From: Contact Centre (CRM) <contact@ribblevalley.gov.uk>
Sent: 16 February 2024 10:04
To: Planning
Subject: Planning Application Comments - 3/2023/1011 FS-Case-587367485

Planning Application Reference No.: 3/2023/1011

Address of Development: 41-43 Wellgate , Clitheroe, BB7 2DP

PROPOSED GROUND FLOOR PLAN - 108m²
1:100 @ A3

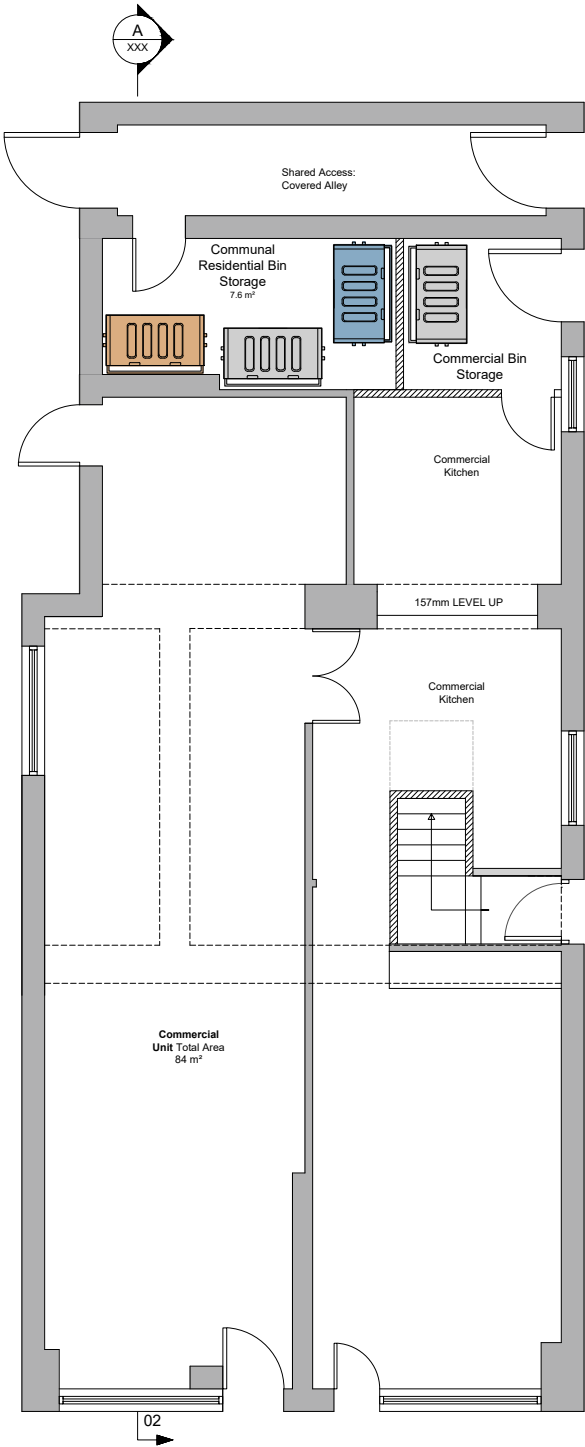
Comments: I have concern for the door shown near the back of the property, [REDACTED] 39 and 41 [REDACTED] bin there also to exit the back of the property you would have to use [REDACTED] at [REDACTED] back passage and would require the occupant of the ground floor [REDACTED] needing a key to the [REDACTED]
